Contact: Chris Dwyer
Our Ref: 52/2025/7/2
Your Ref: SSD-85939708

**Request for Comment – State Significant Development
Rothbury Battery Energy Storage System – SSD-85939708**

Council has reviewed the EIS by Aecom Australia Pty Ltd dated 20 April 2026, Job No: 60757361. I also refer to our previous comments on draft SEARs for the project dated 25 June 2025 (Our Ref: 52/2025/7/1).

Figure 5-1 Theoretical visibility of the Project based on terrain surface only (i.e. screening by vegetation or built form was not considered)

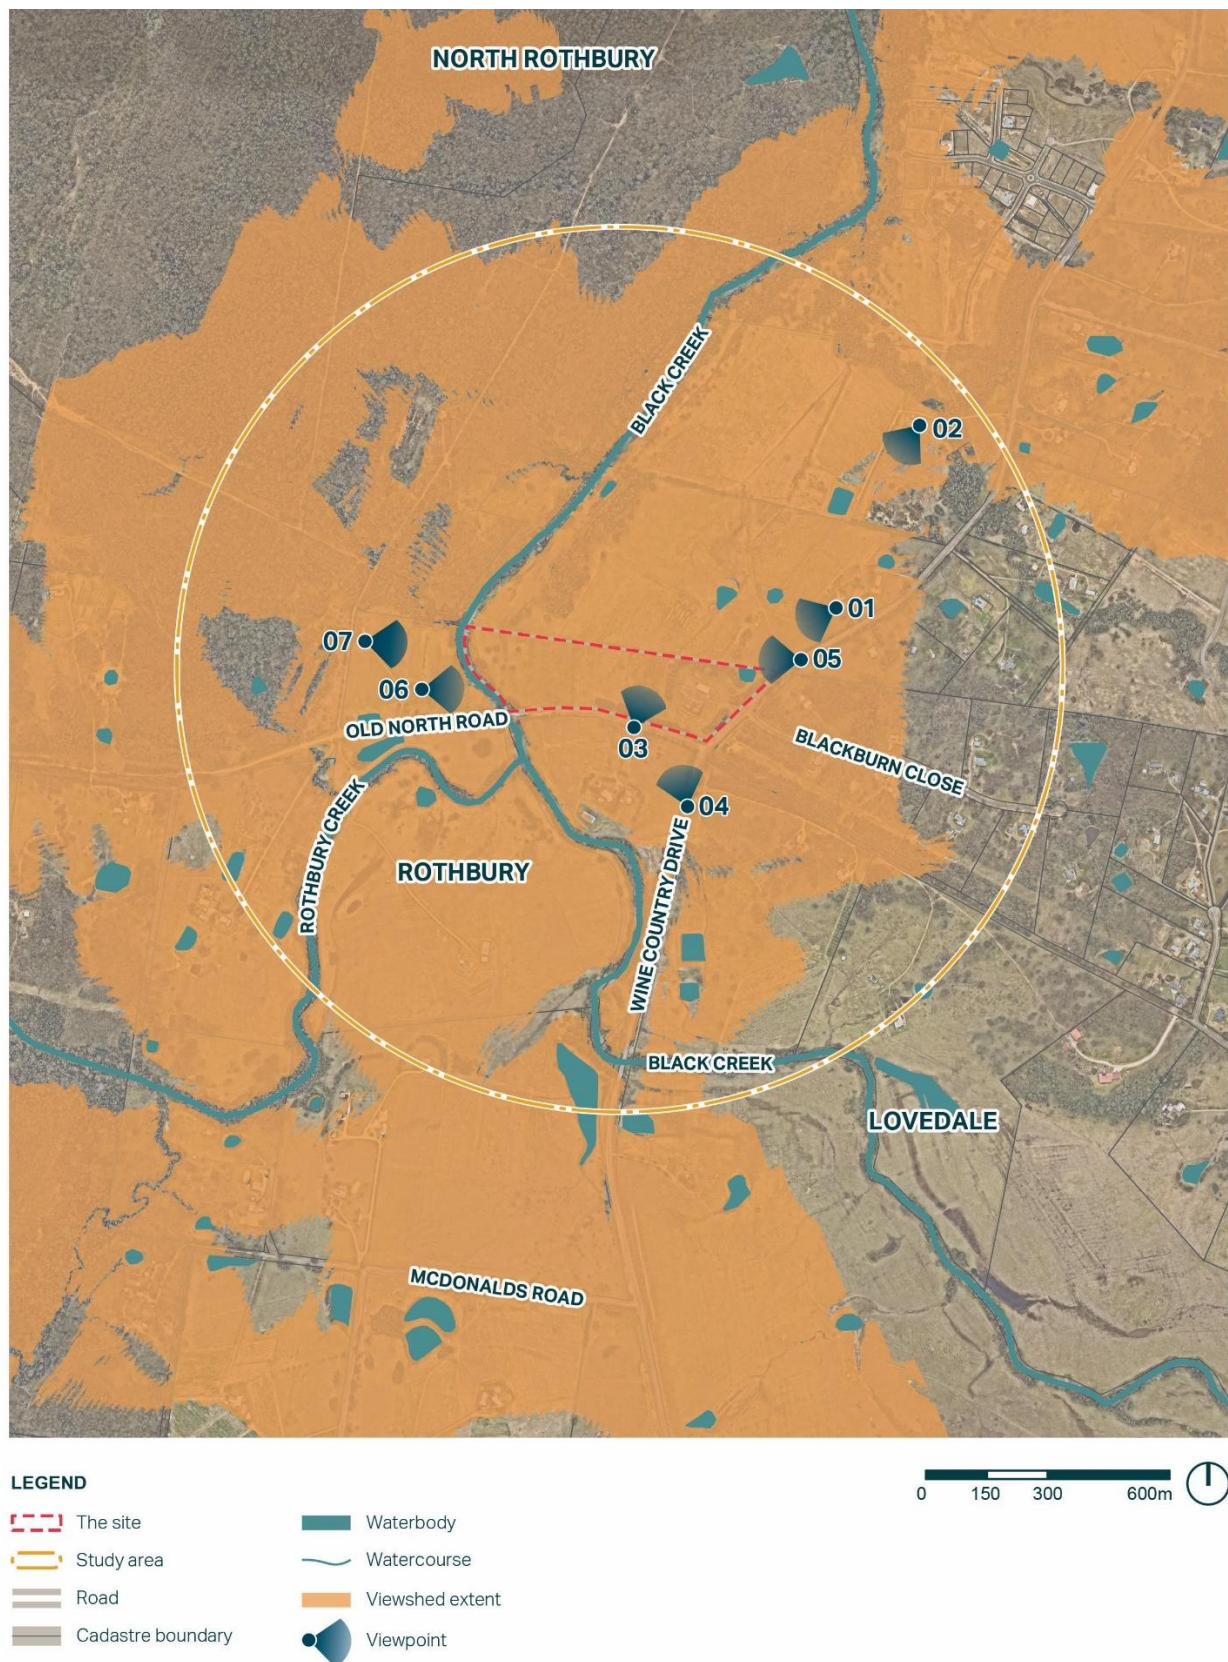
It is reiterated that the need for an 8 metre fence to mitigate acoustic impacts suggests that the impacts of the proposal are beyond that which is appropriate for the site.

Due to the importance of the scenic qualities of the area to the tourism industry, it is not considered that the current extent of the visual impact assessment is sufficient.

It is recommended that additional viewpoints be prepared along Wine Country Drive and Old North Road, to enable a more comprehensive analysis of the impacts to the scenic qualities of the area.
